(Revised) STAFF REPORT BIG CREEK TRAILS REZONE (RZ-15-00001)

RE: Big Creek Trails (RZ-15-00001)

DATE: November 15, 2016

Big Creek Fish Ladder

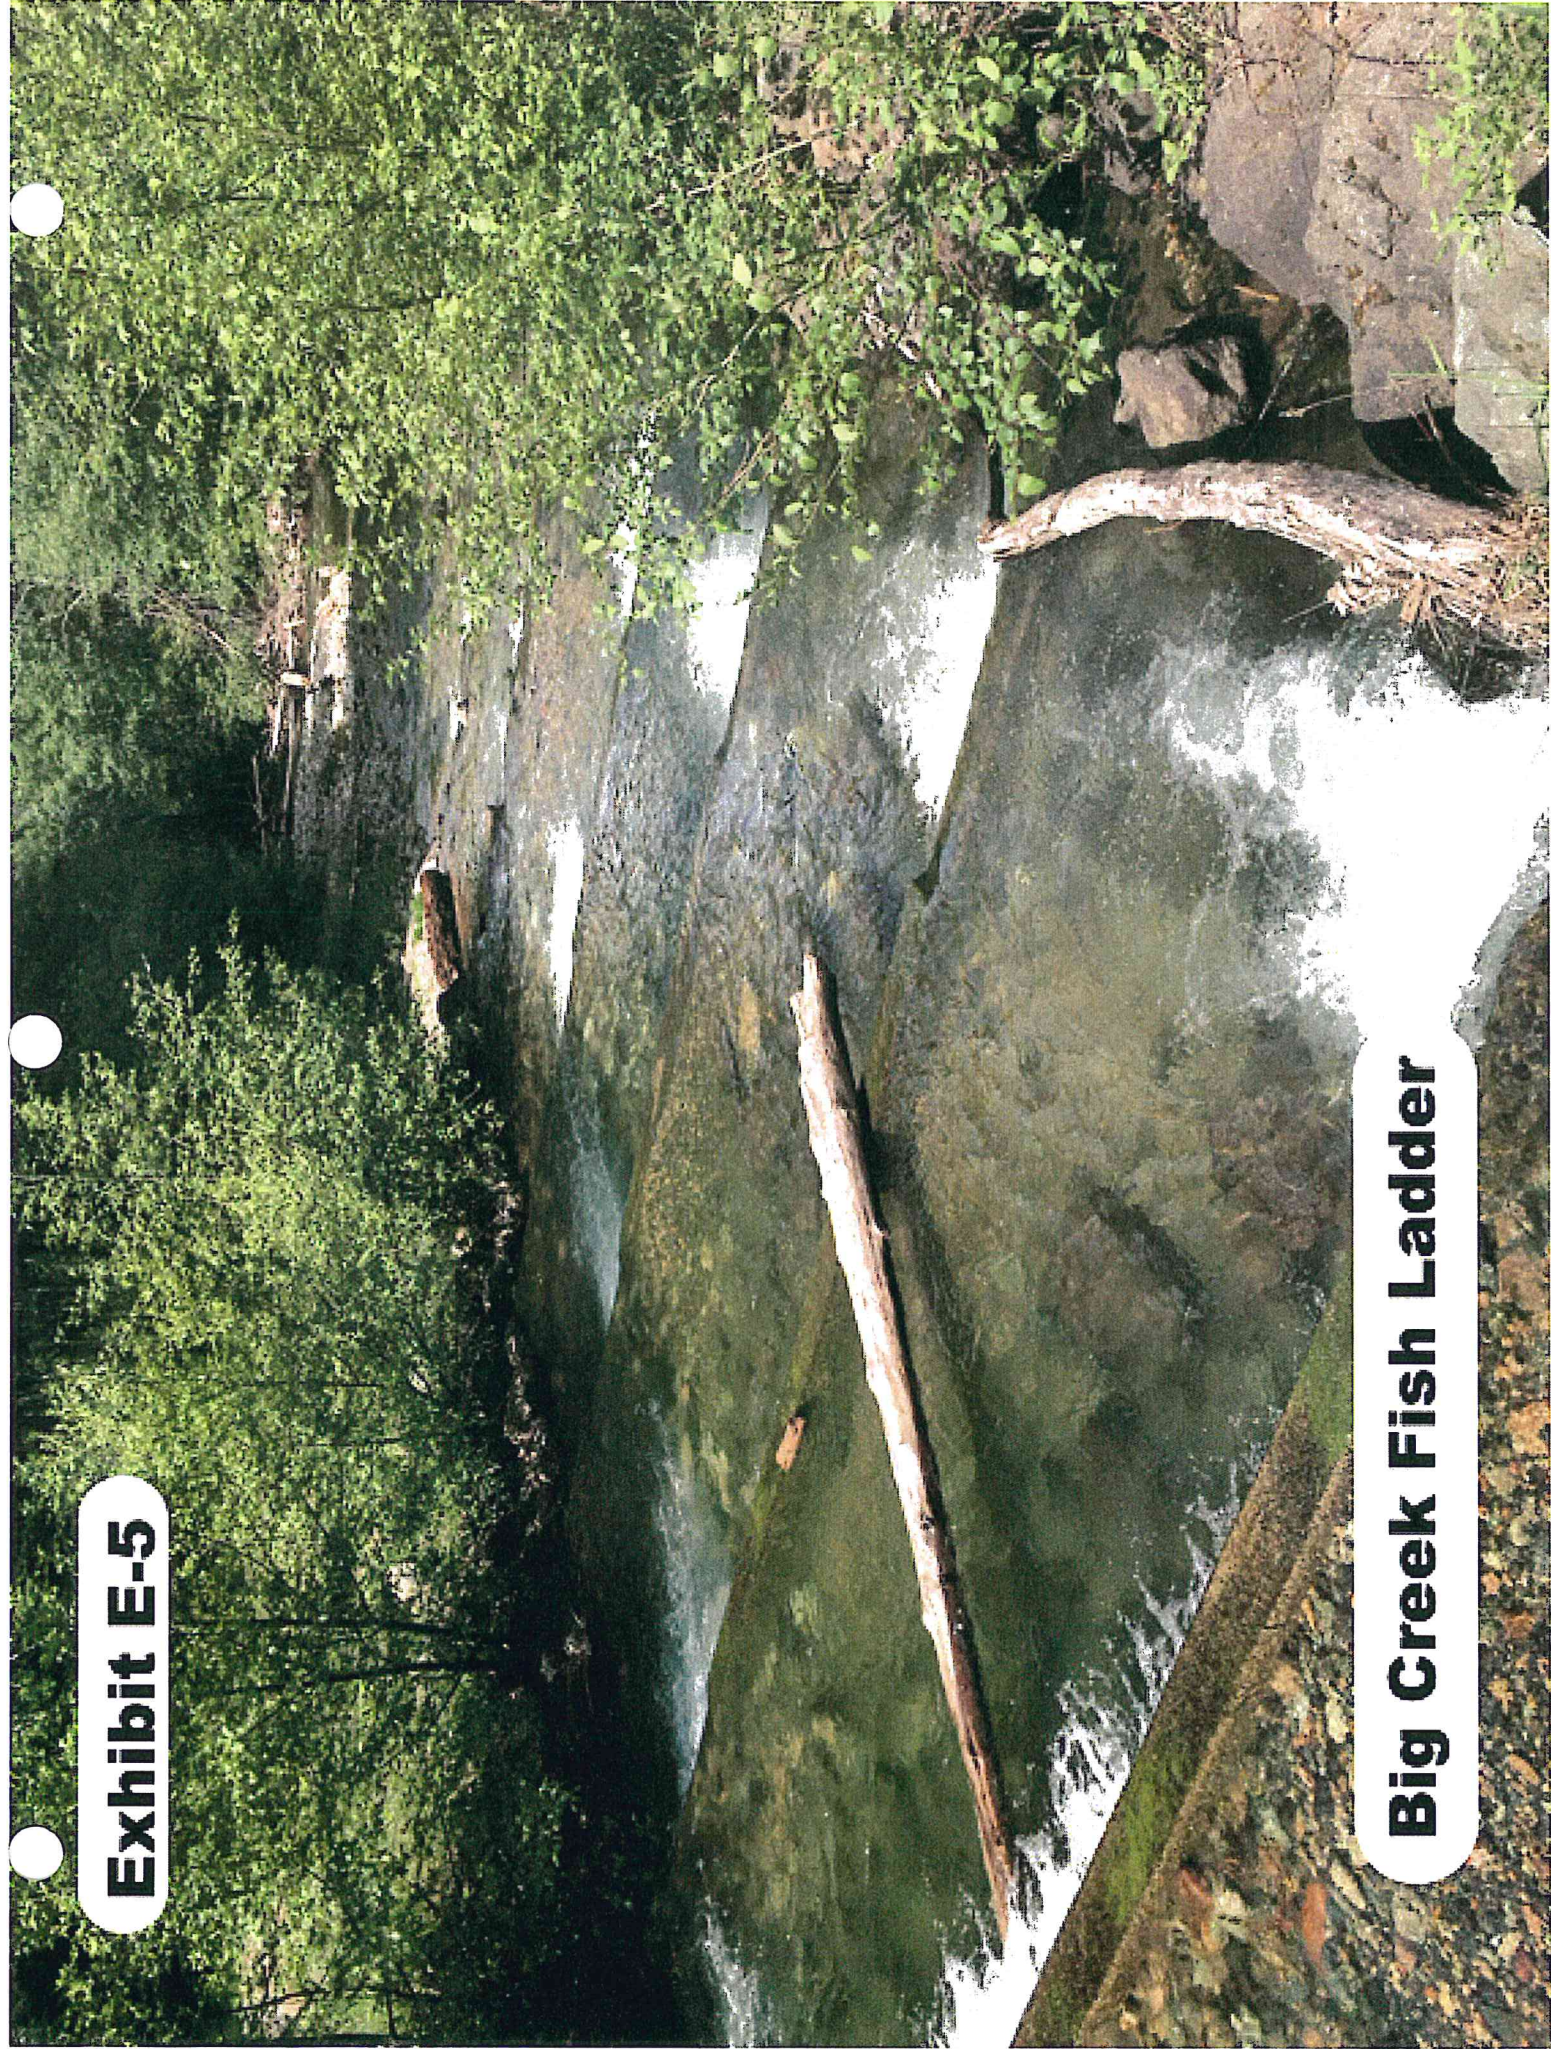
- m. Upon approval of the Final Development Plan for the PUD and prior to the recording of the first plat, the applicant will provide WDFW with easements required to maintain the diversions and fish screens on Big Creek.

RZ-15-00001

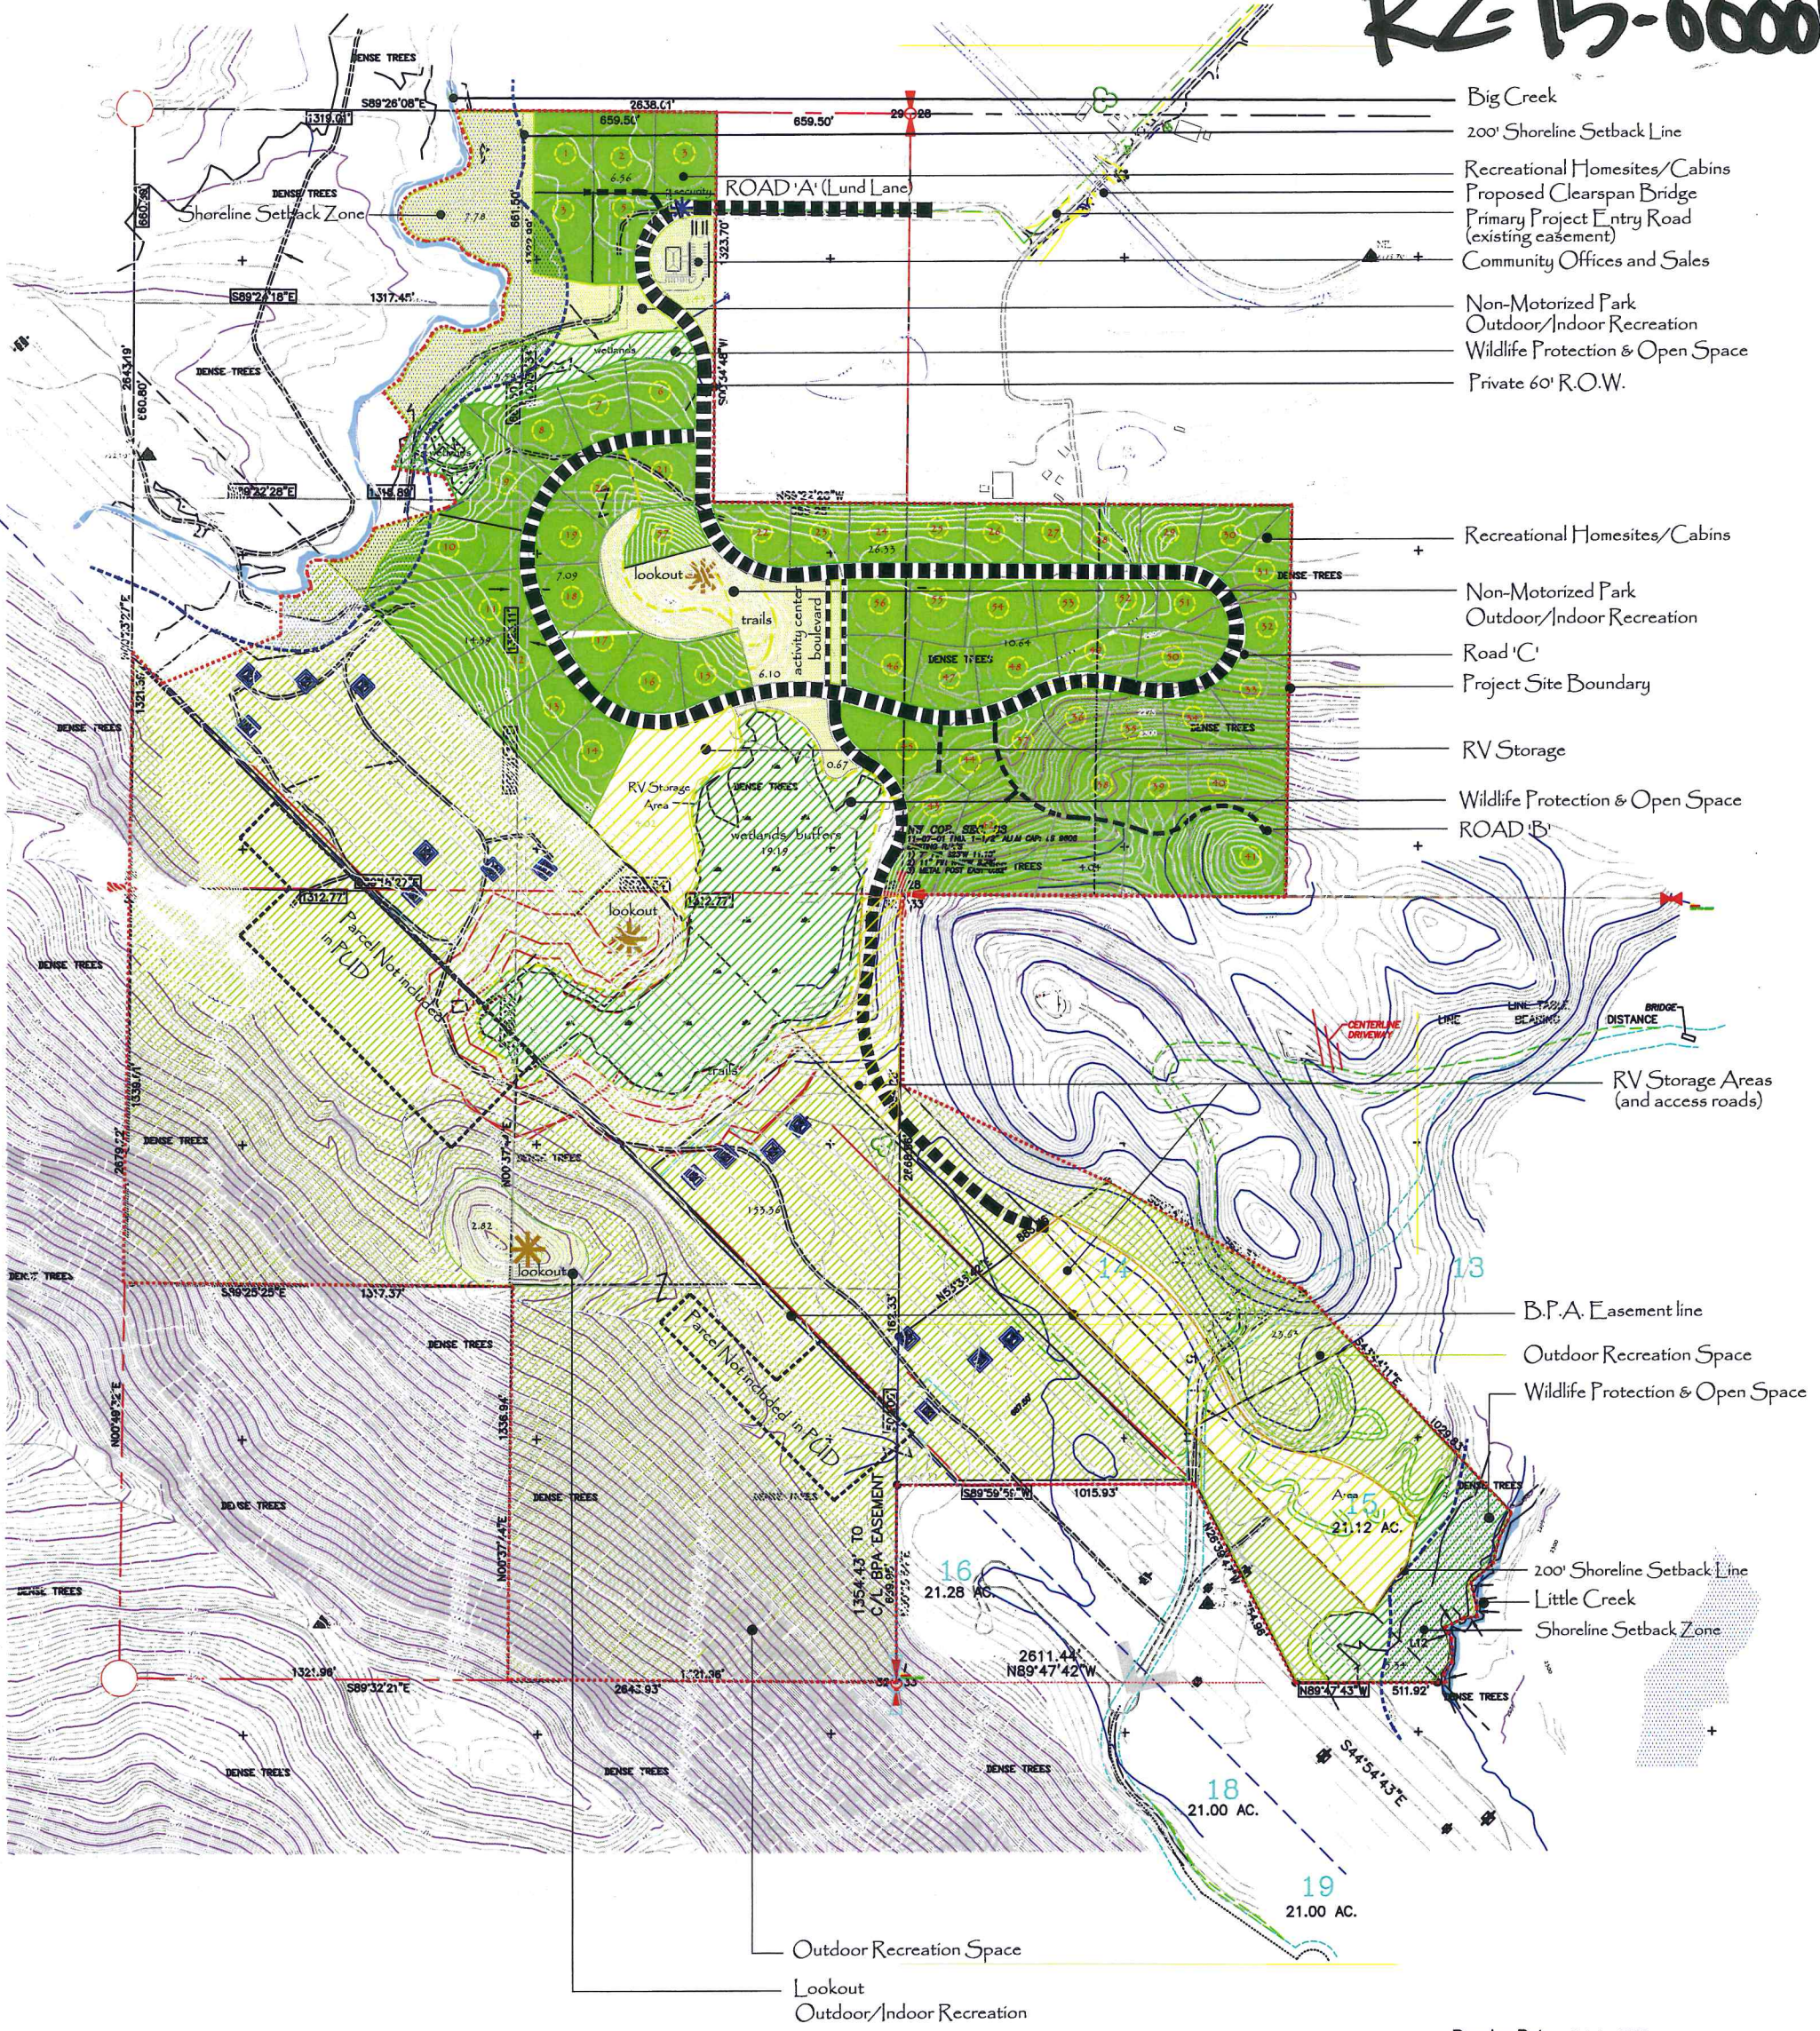
- j. The applicant shall relocate lots 57 and 58 to an area adjacent to or in close proximity to the larger residential area identified on the site plan that has been submitted with the PUD application as conditioned as follows:

- 1) The current planned residential foot print, identified on the site plan that has been submitted with the PUD application, may be enlarged a maximum of 7.5 acres to absorb the relocation of Lots 57 and 58 (identified on the site plan attached to the PUD application);

- 2) The current location of the home sites that may be relocated within the site as long as any additional impacts are mitigated.;
 - 3) The road that was planned to connect the two home site foot print areas will not be required as the roads of the PUD will be built to the public road standards as defined in Kittitas County Code Title 12; and

- 4) The recreation storage area may be moved or split into two locations with one being located near or adjacent to the northern boundary of the BPA power line easement and not adjacent to the residential area.

RURAL AREA PUBLIC ROADWAY DESIGN STANDARDS

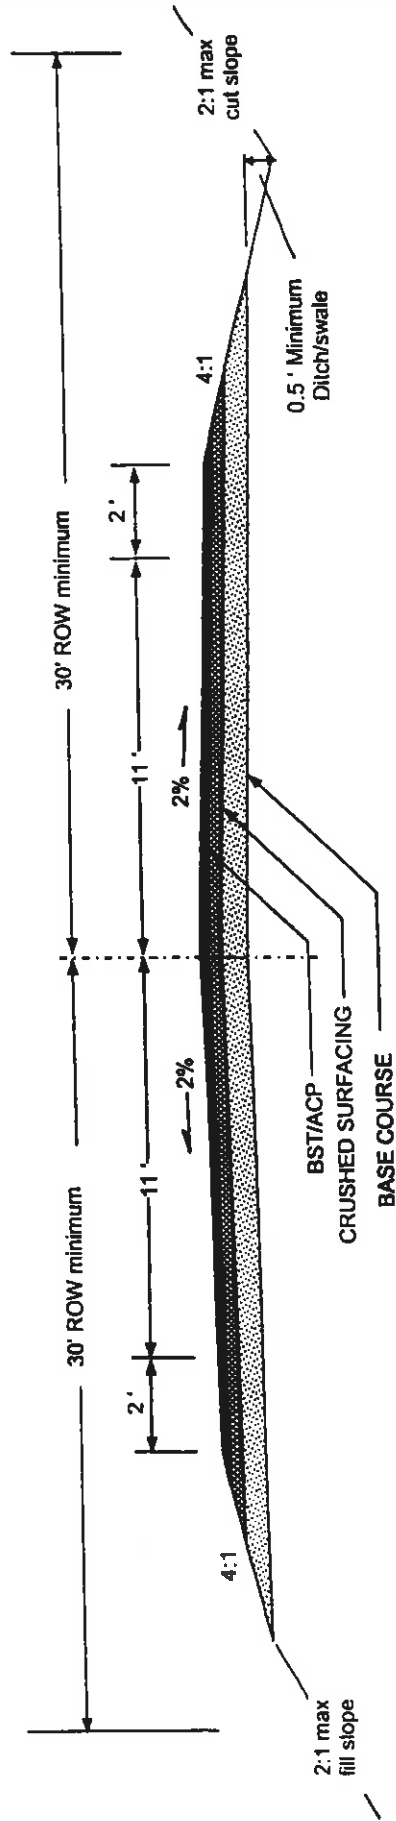
- c. Construction of Road "A" will be a private road built meeting public road standards and dedicated for public use. Construction of Road "B" will be built to current private road standards with an all-weather surface.
